BUILDING CODE OF AUSTRALIA CAPABILITY STATEMENT - Rev A

Property: Sydney Opera House – DA2 Submission

- **Joan Sutherland Theatre Accessibility**
- **Joan Sutherland Theatre Follow Spot Room**
- **Eastern Accommodation**

BCA Assessment (Joan Sutherland Theatre Follow Spot Room Project ONLY)

Location	OT VA	Drawing No:	49-OT-SC019	Sheet:	DA450	Rev:	A	A1
----------	-------	-------------	-------------	--------	-------	------	---	----

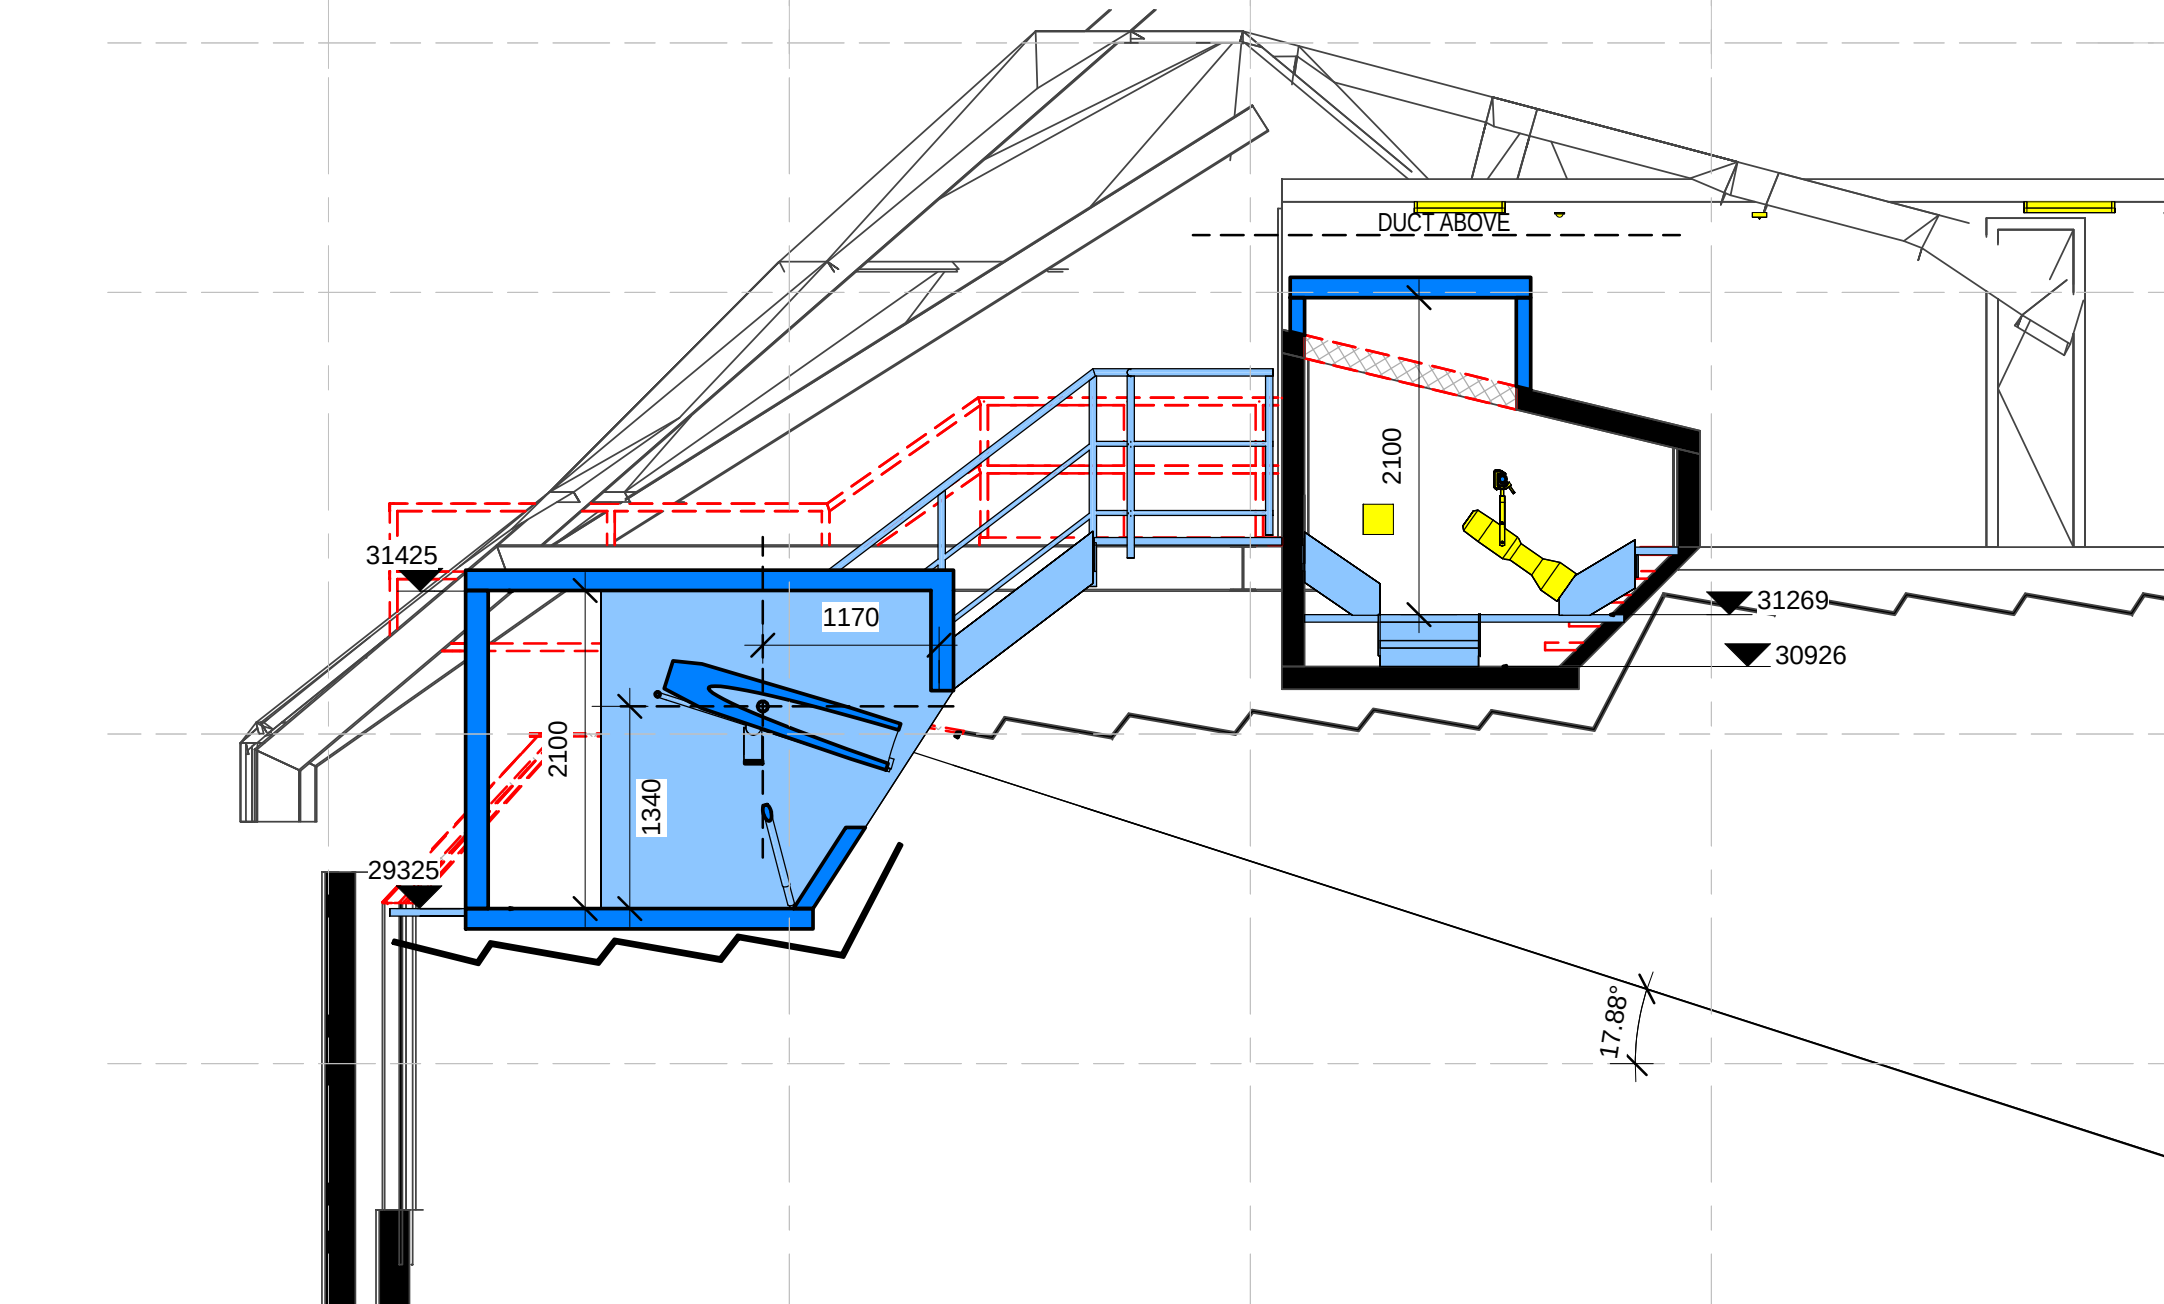
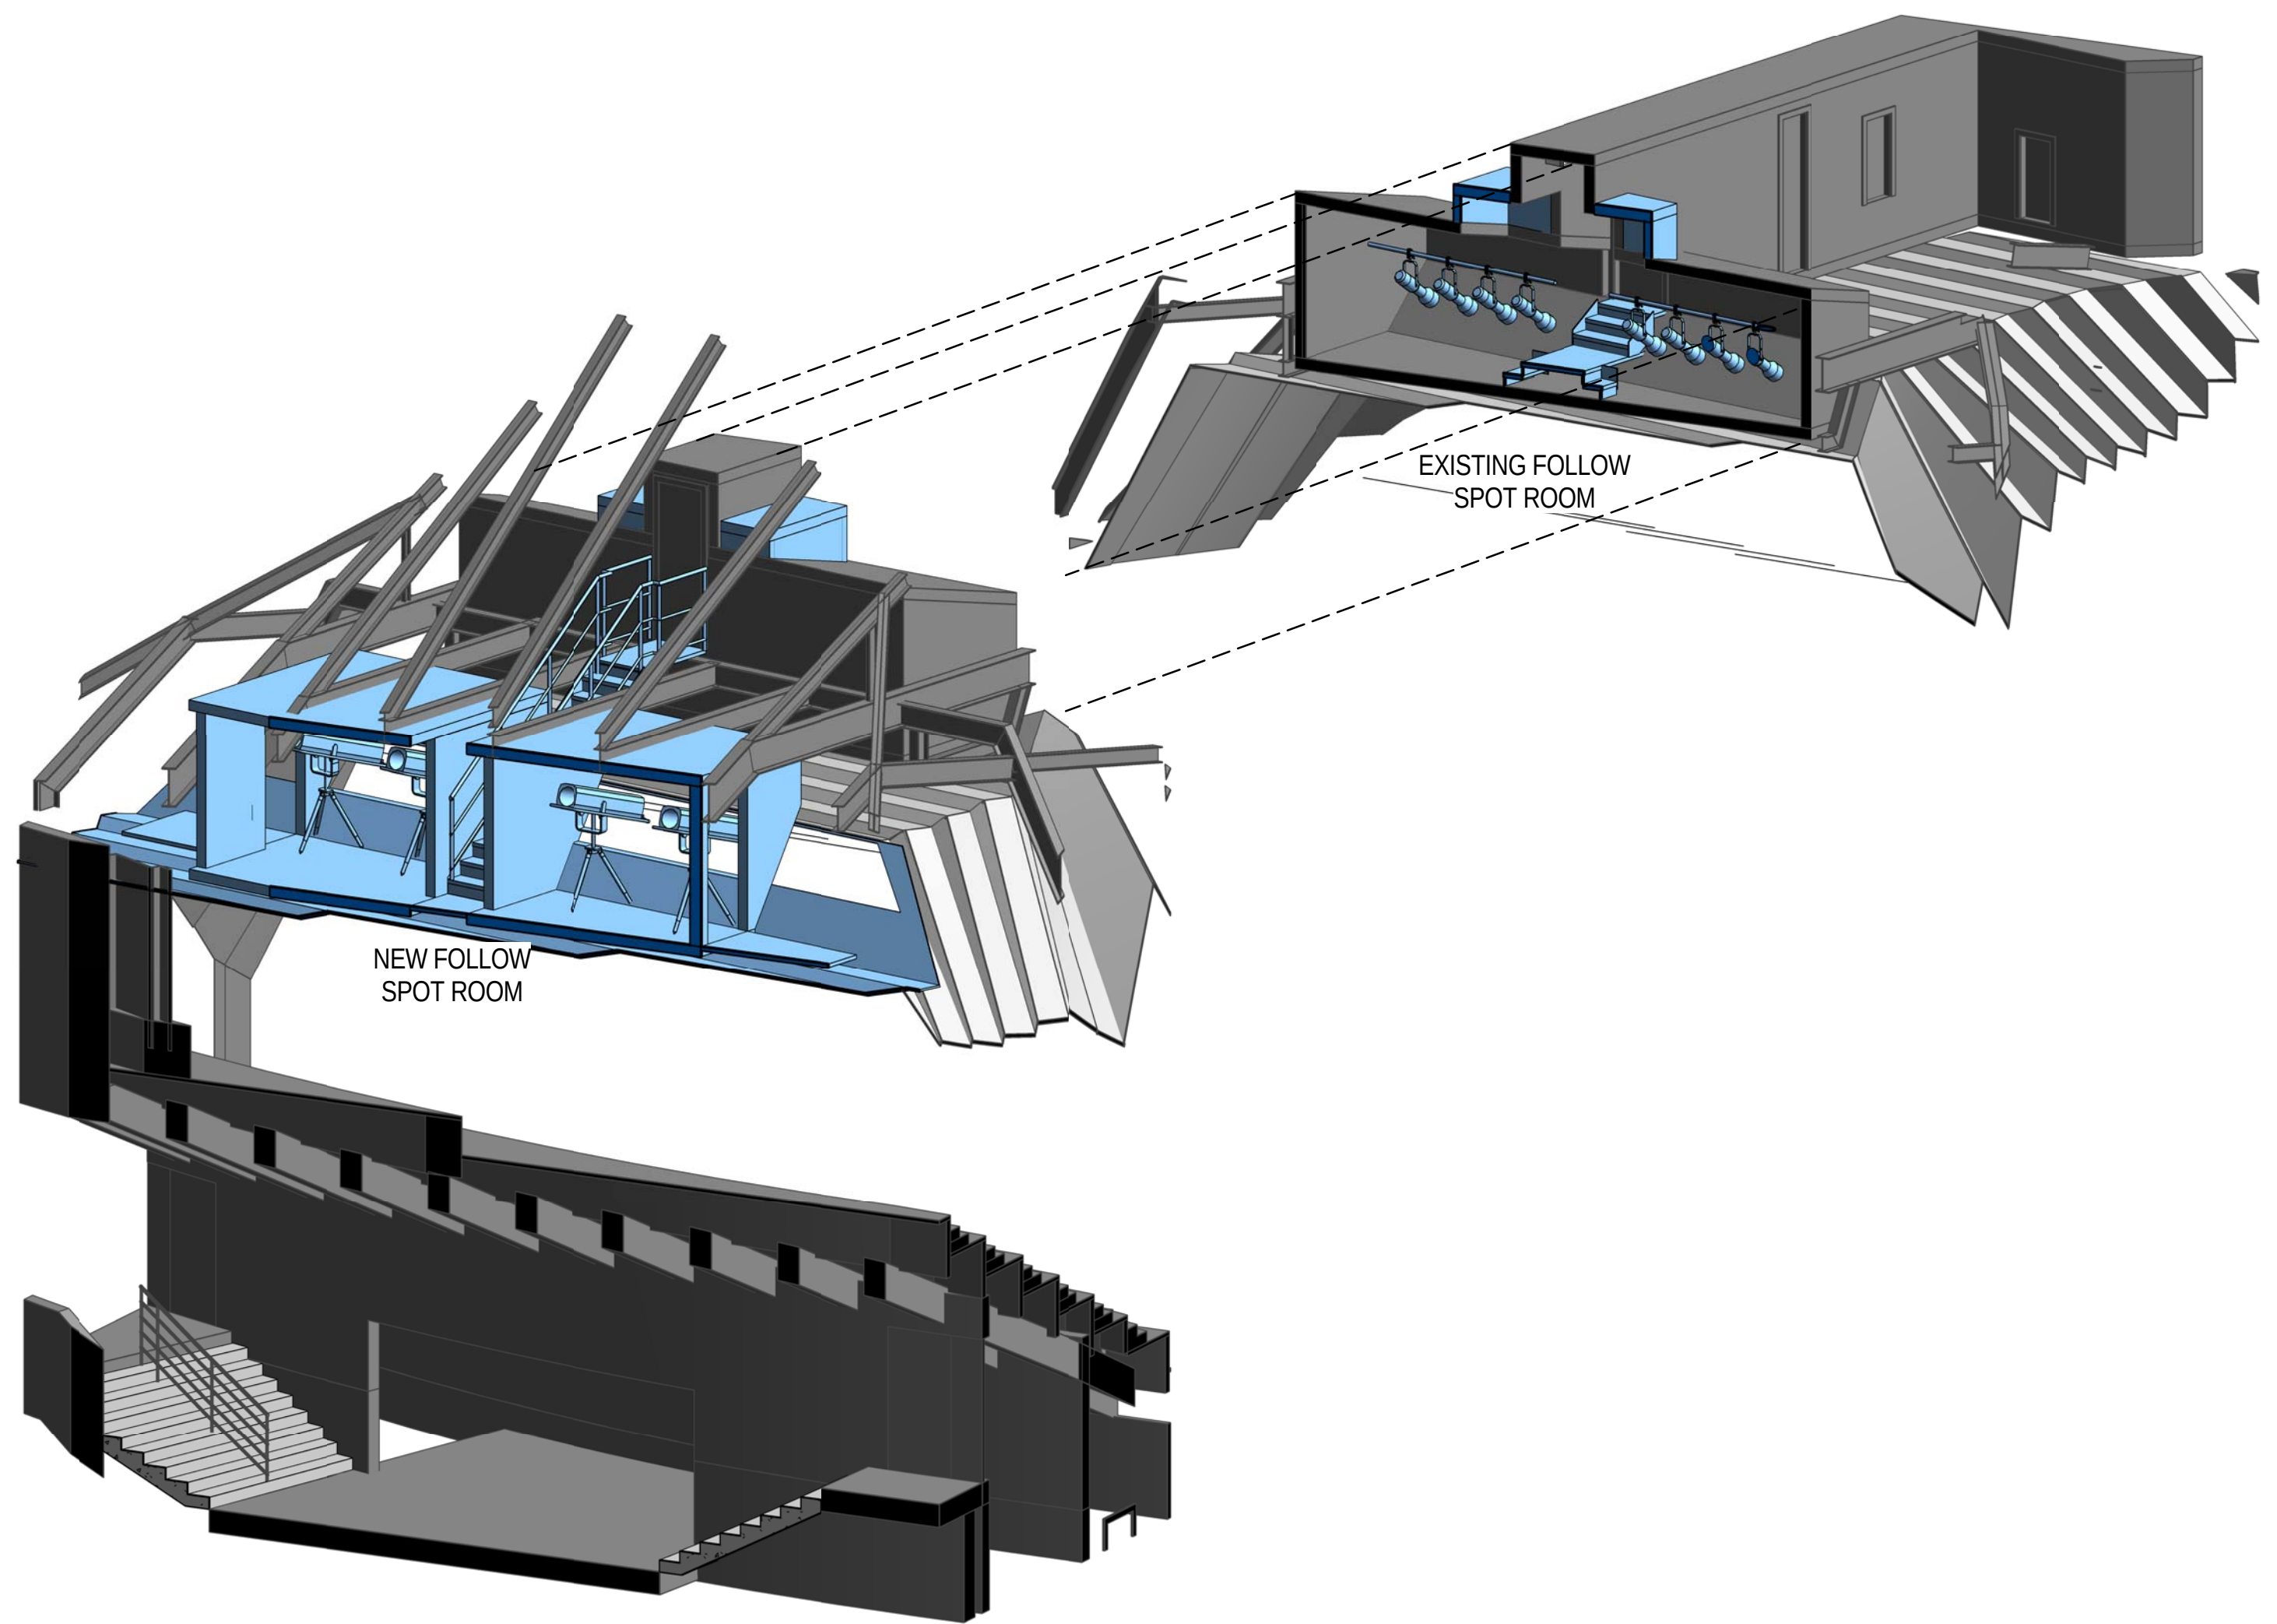
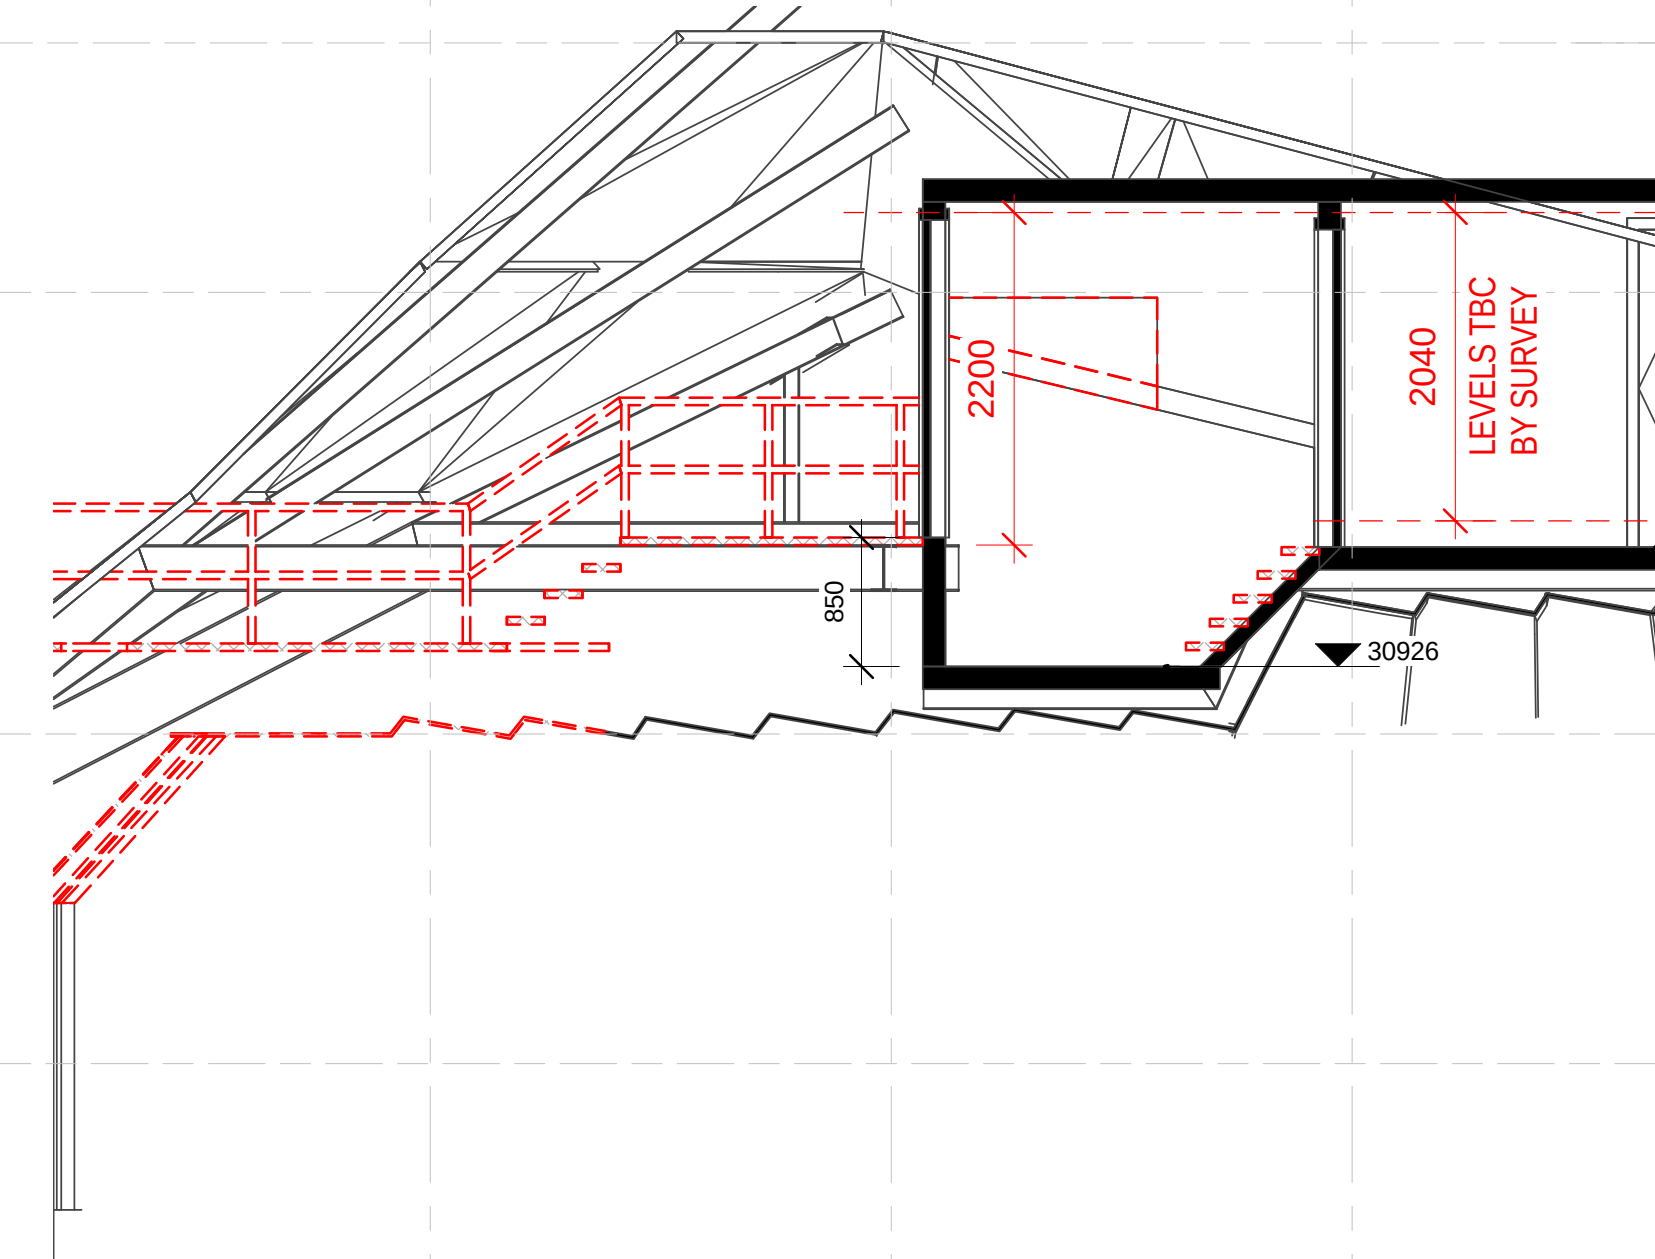
Only one exit from the existing and proposed Follow Spot Rooms is proposed where no less than two are required. The Fire Safety Engineer will need to consider the feasibility of a Performance Solution. It is understood that the area in question will have low number of trained staff present at various times.

Plans illustrating the existing exits are required to be developed for further assessment of the altered travel distances due to the new wall layouts. The BCA deemed-to-satisfy travel distance limitations are 20 m to an exit, or to a point of choice of travel to two different exits, with an overall distance of 40 m to the nearest of these two exits. And 60 m between alternate exits when measured back through the point of choice. The investigation will consider these parameters but only to the extent where an existing situation has been made worst by the proposed design. Any deficiencies can be considered by the Fire Safety Engineer
